WEST SUSSEX COUNTY COUNCIL CONSULTATION

TO:	Arun District Council FAO: Miss K Welch
FROM:	WSCC – Highways Authority
DATE:	24 February 2026
LOCATION:	East Preston Depot Station Road East Preston BN16 3RE
SUBJECT:	EP/1/26/PL Change of use of A1 buildings & yard to B8 use with elevational alterations, including solar panels and changes to the parking layout. This application is in CIL Zone 4 (Zero Rated) as other development.
DATE OF SITE VISIT:	n/a
RECOMMENDATION:	Advice

DRAWING TITLE
**Site Layout Plans
 As Existing & As Proposed**

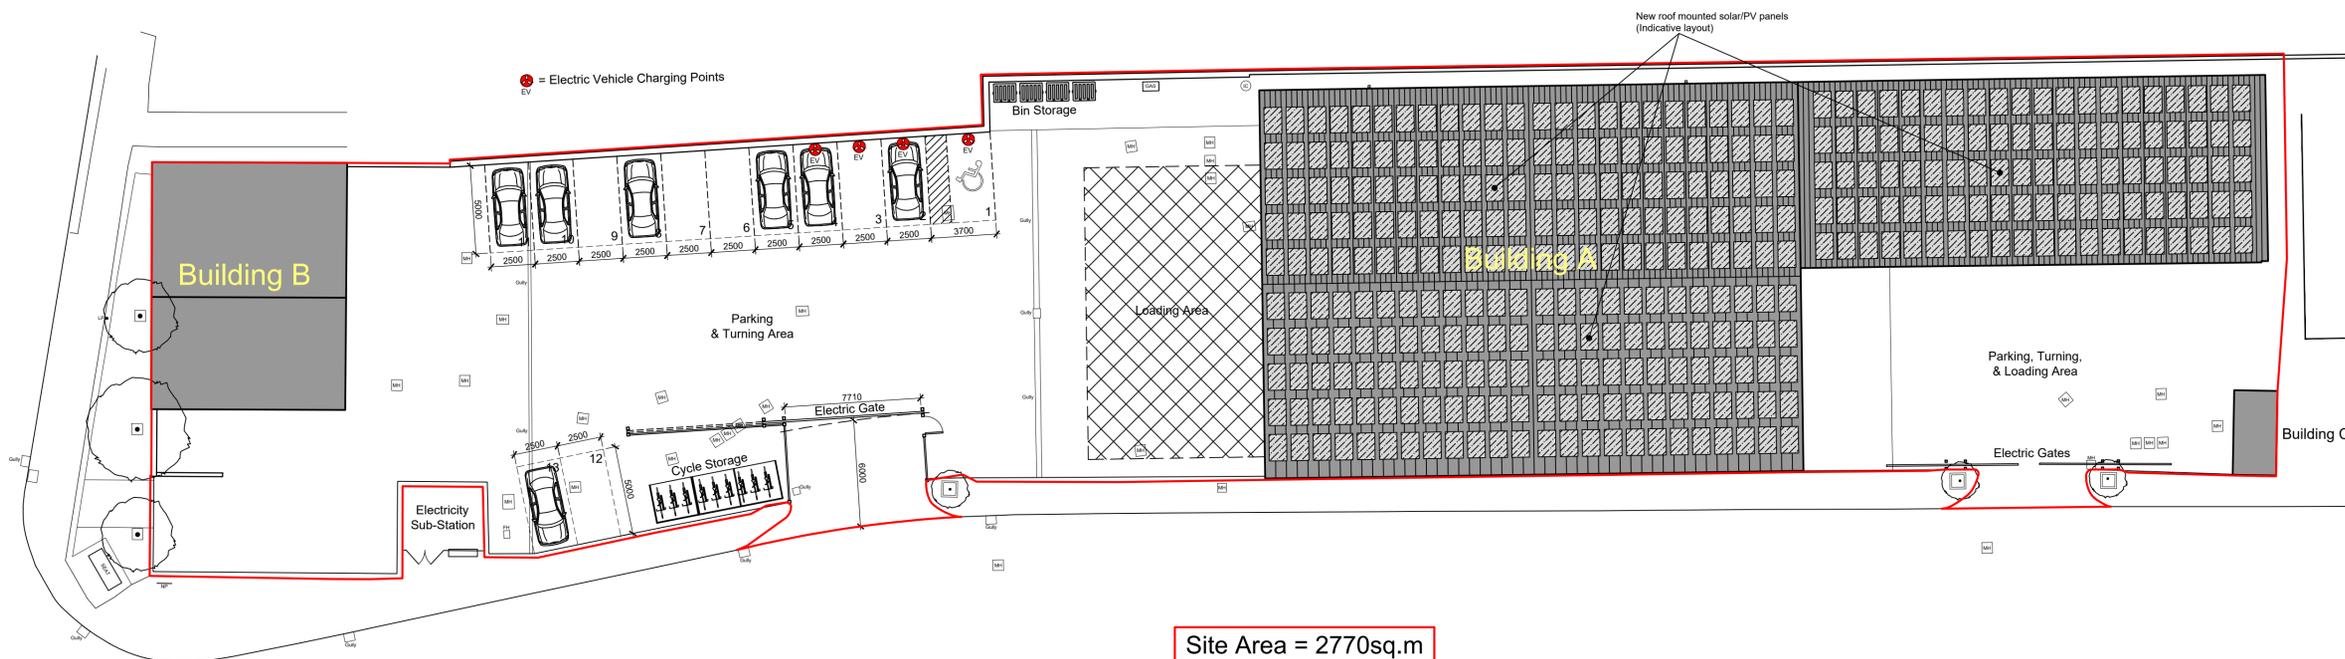
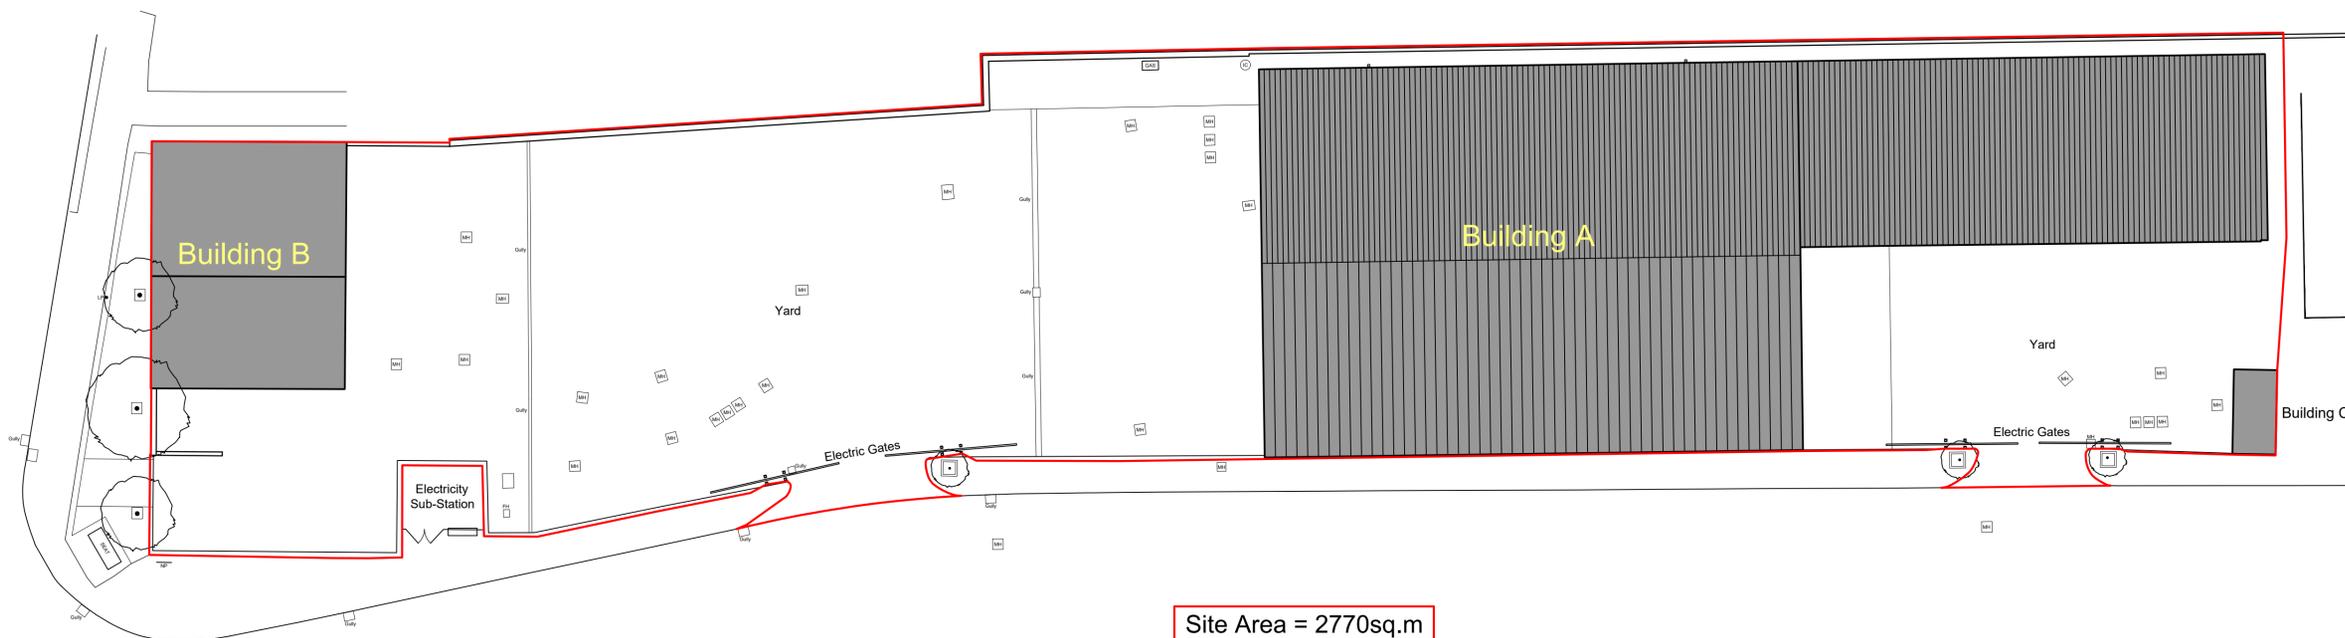
It has been noted that the gate present at the western access- serving the car park- will be set back further into the site. This would facilitate a waiting vehicle wholly off the carriageway whilst the gate is operated. The 6m depth provided is considered sufficient to

accommodate an average sized vehicle and thus enabling the free flow of traffic along Station Road. This 7.7m wide bell mouth access facilitates two vehicles travelling in opposing directions navigating the access without conflict.

The sliding gate could at times obstruct access to the cycle parking location, however it is considered that this would be an infrequent and temporary occurrence.

WSCC parking standards outline that a total of 20 parking spaces should be provided to serve the development, at 1 space per 100sqm. A parking accumulation assessment has been carried out to establish the likely parking demand generated by the storage use. The assessment outlines that 10 spaces would likely be sufficient to serve the demand generated. The plans show that 13 spaces are to be provided within the parking area, The LHA consider this a workable solution.

An accessible parking bay has also been included within the design, to ensure inclusive access for all users.

Parking space dimensions are considered sufficient to accommodate an average size vehicle, and there is space within the hardstanding area for cars to turn and egress the site in a forward gear.

In terms of cycle parking, WSCC standards outline that 6 spaces would be sufficient to satisfy the likely demand of a B8 use of this scale; the plans show that a total of 9 cycle parking spaces are to be provided.

Should the planning authority be minded to approve this application, the cycle parking is advised to be secured via a suitably worded planning condition.

No part of the development shall be first occupied until covered and secure cycle parking spaces have been provided in accordance with plans and details submitted to and approved by the Local Planning Authority.

No part of the development shall be first occupied until the car parking has been constructed in accordance with the approved site plan. These spaces shall thereafter be retained at all times for their designated purpose.
